TERRA ASSOCIATES, Inc.

August 5, 2022
Project No. T-8264

Subject: Response to City of Mercer Island Comments
Cheshire Short Plat
7615 East Mercer Way
Mercer Island, Washington

SH2.0

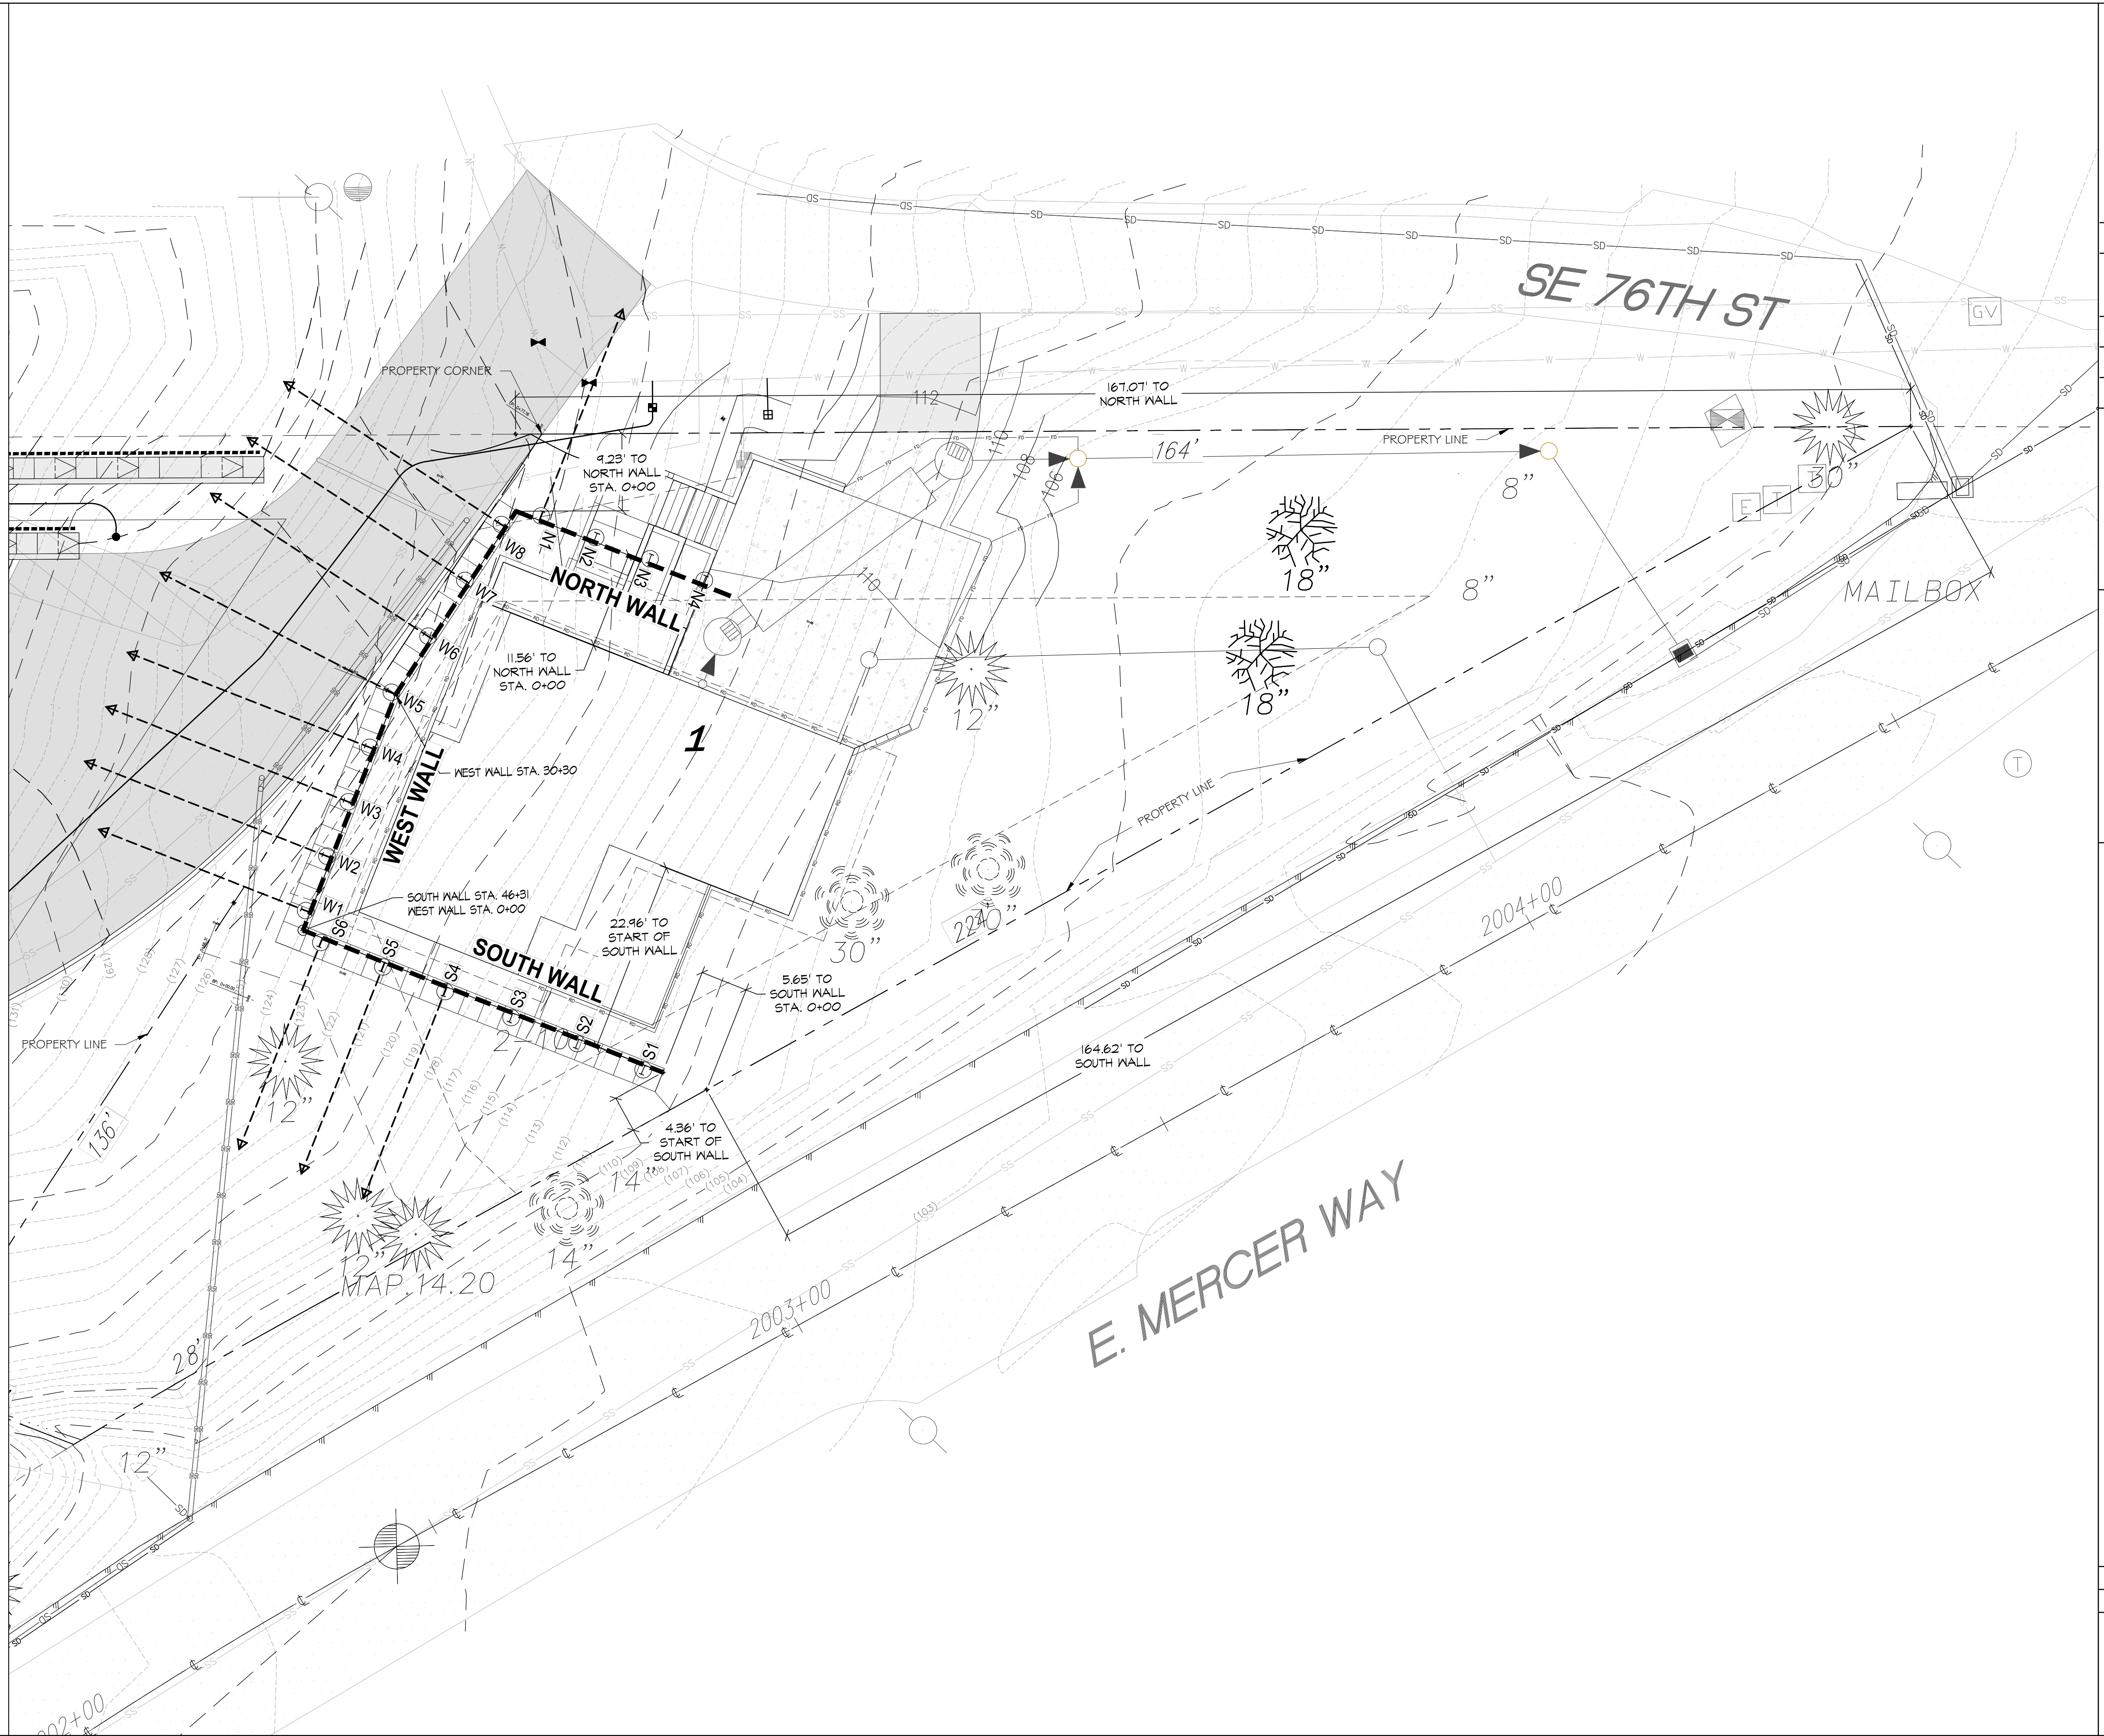
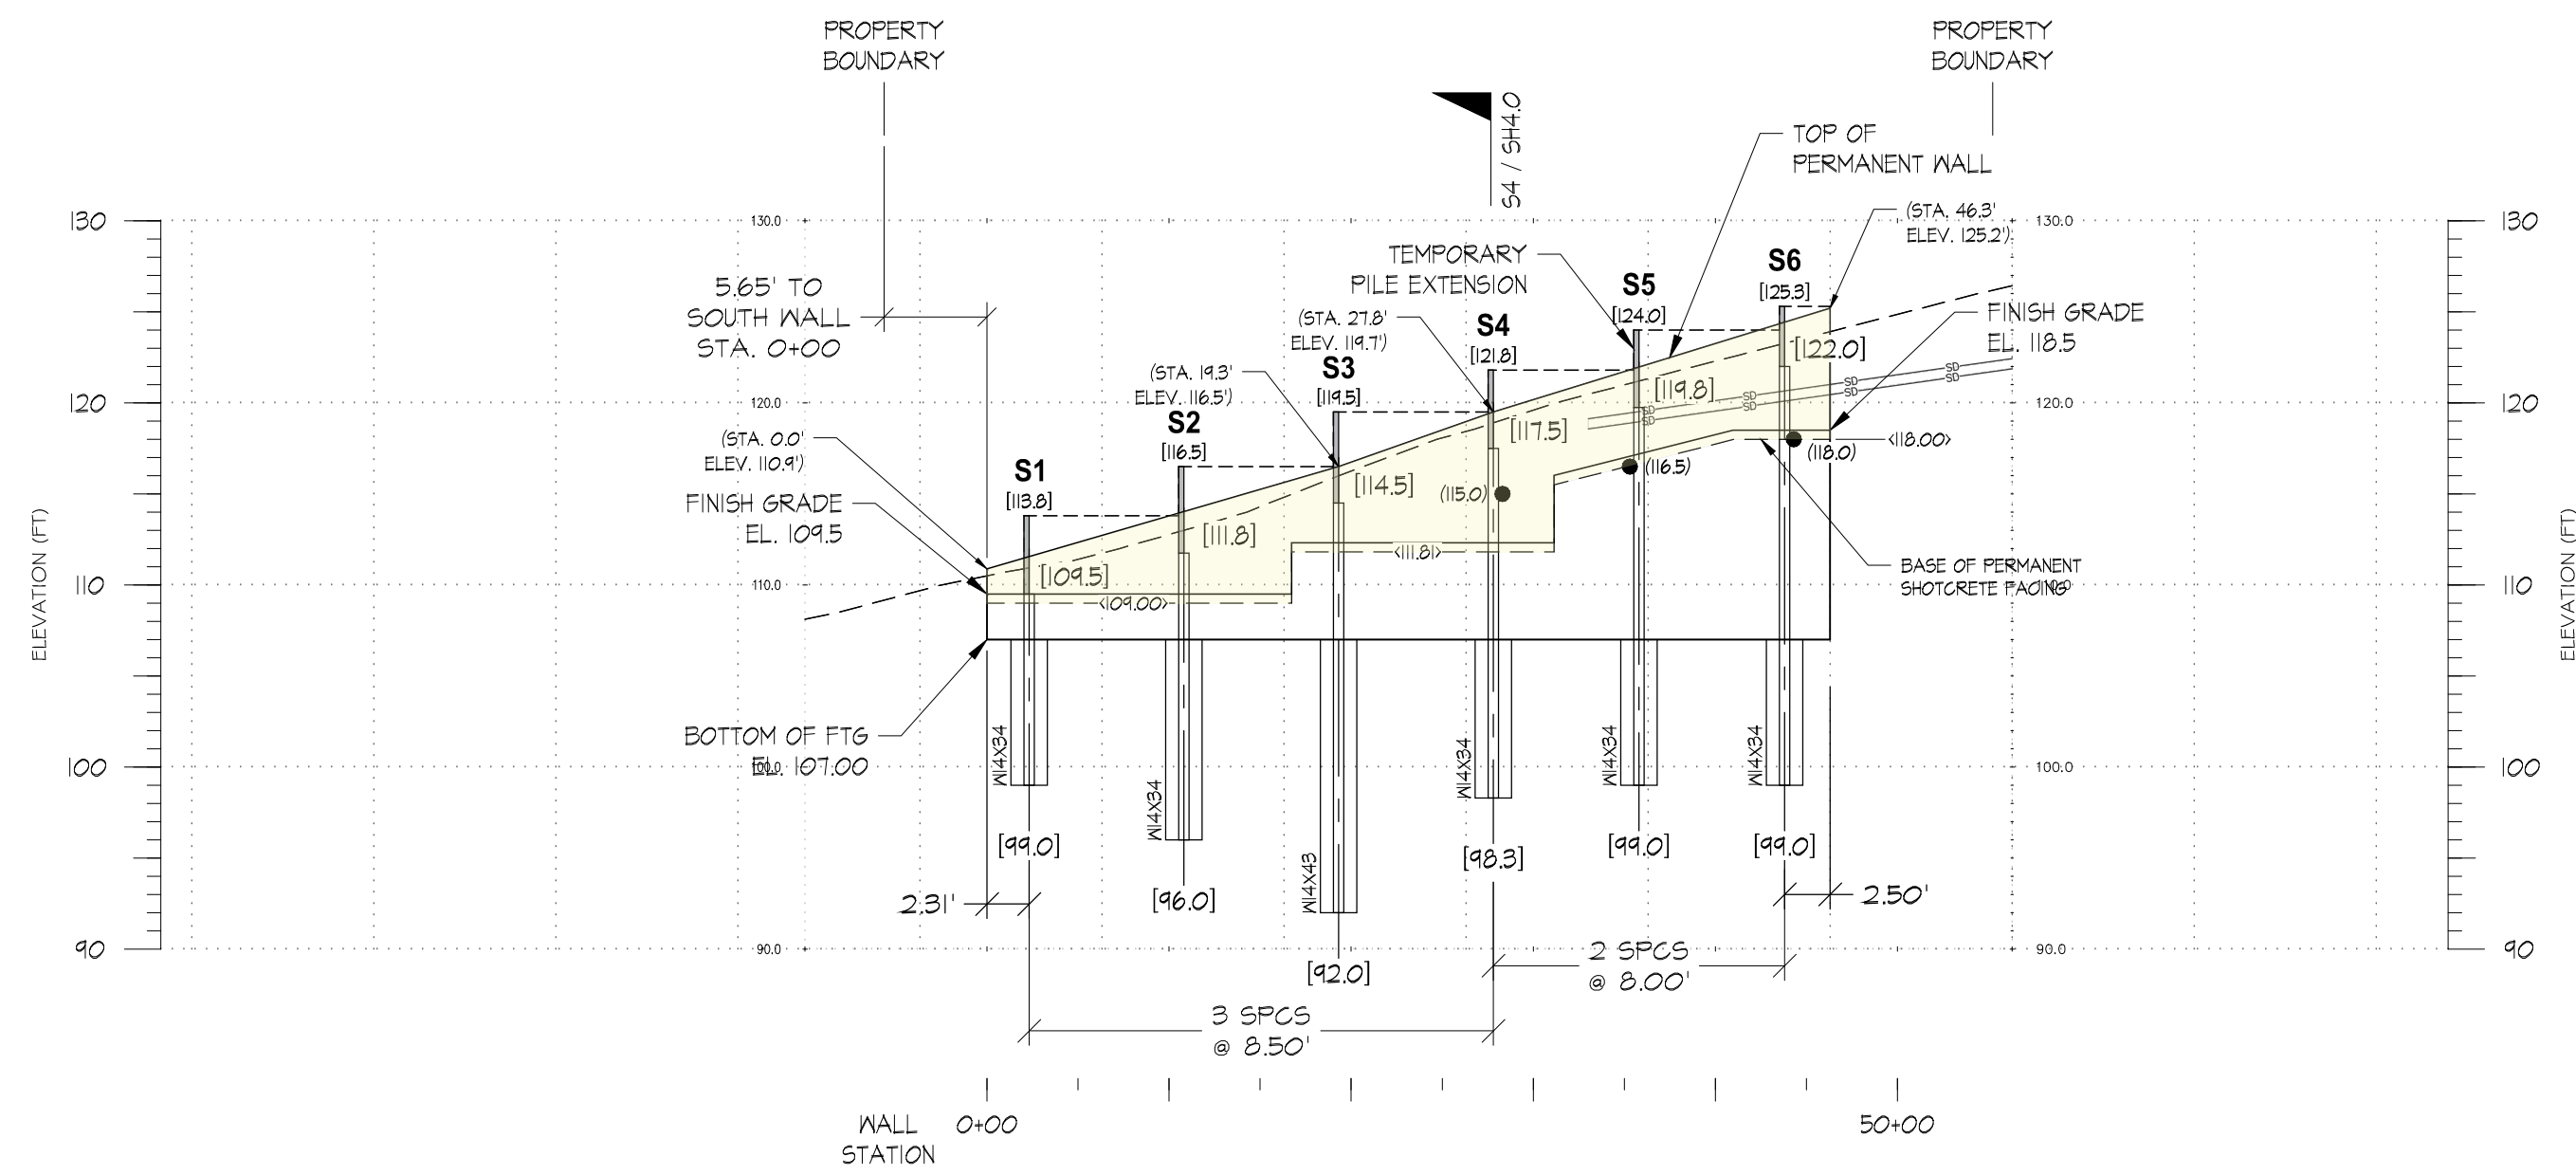
There is also insufficient subsurface information for the location of proposed shoring along the west side of the structure. The type of shoring (ultrablock) requires an open cut. Will the open cut be stable to allow installation of the ultrablock without undermining utilities upslope? Is there enough space to install ultrablock? An alternate shoring system or temporary construction easement from the uphill property owner should be considered if these issues cannot be resolved.

If an open cut is proposed, slope stability analyses of the temporary cut will be required. Geotechnical engineer should include discussion on potential undermining or relocation of existing utilities upslope given the results of the stability analyses.

Provide location and extent of proposed shoring including top and bottom shoring wall elevations. Provide detailed shoring design and calculations for review.

We respectfully disagree that there is insufficient subsurface information to analysis the use of Ultrablock Shoring for the proposed excavation. The referenced geotechnical engineering addendum outlines the assumptions used to determine the system is viable on a temporary basis. Yes, a temporary open cut is required to install the Ultrablock shoring, however, as noted on the wall details, the excavation for the wall should be completed so that exposed soils are completed covered at the end of the workday thus reducing the potential impact from an open and unsupported excavation.

The location of the proposed shoring is shown on the design plans. The shoring design and calculations are in the referenced geotechnical engineering addendum.
